From: Hannah Riddle on behalf of Planning.Responses
Sent: 15 June 2022 16:35
To: Planning Scanning
Subject: FW: P/60/22/PL

P/60/22/PL

Grey Barn Church Lane Pagham PO21 4NX

Replace existing conservatory with front porch, single storey rear extension and dormer windows. Extension of existing garage and part conversion to tourist accommodation. This application may affect the setting of a Listed Building.

PROPOSED SOUTH ELEVATION

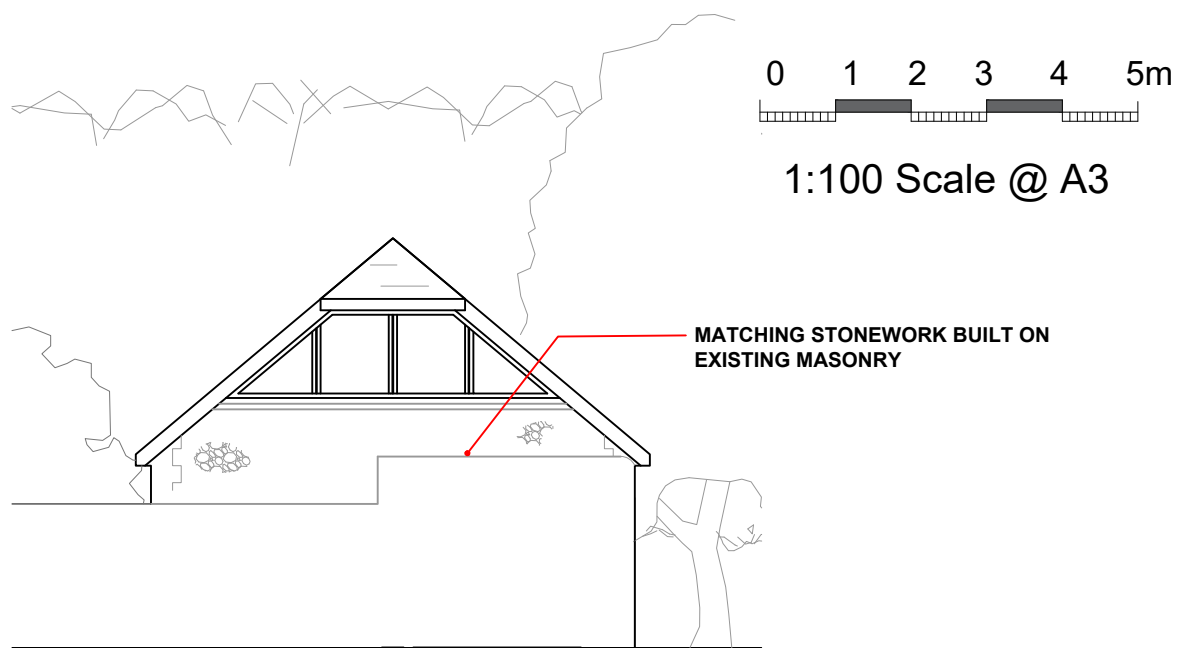
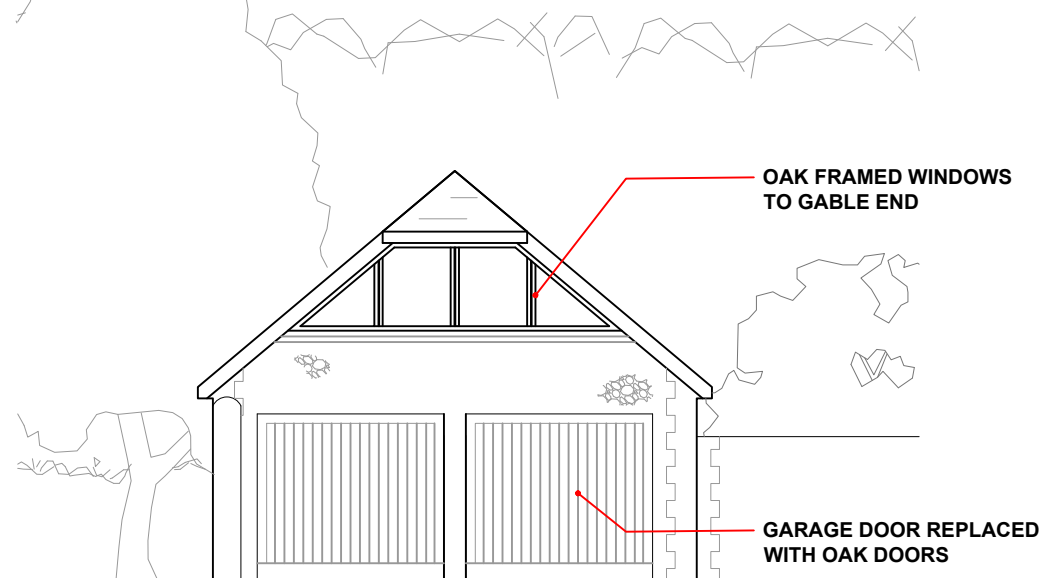
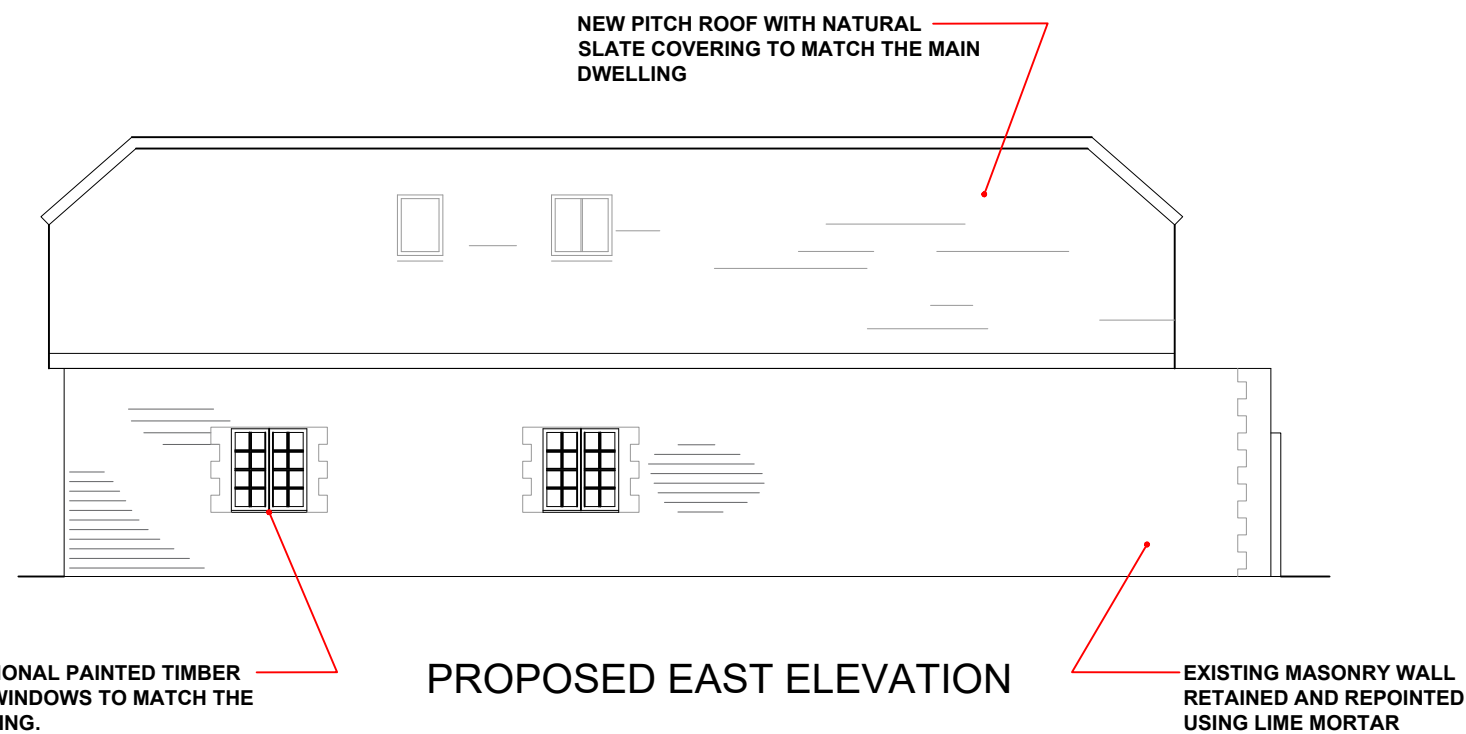
The removal of the existing conservatory will result in the loss of a poorly designed structure of inappropriate materials. This will enable the elevation to be better viewed and appreciated. The replacement oak framed porch appears to be designed so that it is sympathetic to the building and will have a positive impact. It is assumed that the oak will be left to silver, is this correct?

The single storey extension to provide a utility is cleverly designed in that the roofline follows that of the existing house, and will replicate the existing materials. However, will all three elevation be in matching stone? If so, will this be the same stone as the gable? Whilst the use of the stone is acceptable, this would be subject to details of the materials and a sample panel. If alternate materials are also to be used on some of the elevations, I would need to understand what these would be. Such information can be provided for by way of condition.

The additional windows do not seem to be causing harm and are reflective of the existing ones. It is very positive to understand that all of the UPVC windows will be replaced with traditional painted timber ones. It would help it understand more about these windows and details could be provided by way of condition. This would need to include details of their design/appearance, specification, glazing bars, glazing, method of opening, location within the window opening and finish. Such information should be provided in the form of drawings and sections of an appropriate scale.

The new building has clearly been designed so that it reflects elements of the dwelling such as the barn hipped roof, and use of materials. It is also positive to note that the windows and doors will be timber and the existing masonry wall to the south and east elevation will be repointed in appropriate materials – details could be provided by way of condition to ensure they are appropriate for the building. The existing positive materials i.e. stone should be reserved and reused as part of the new building. I am also of the opinion that, subject to the use of high quality materials and finishes, that it will form an acceptable element of the street-scene. Such a view will ensure that views of Little Welbourne will not be affected.
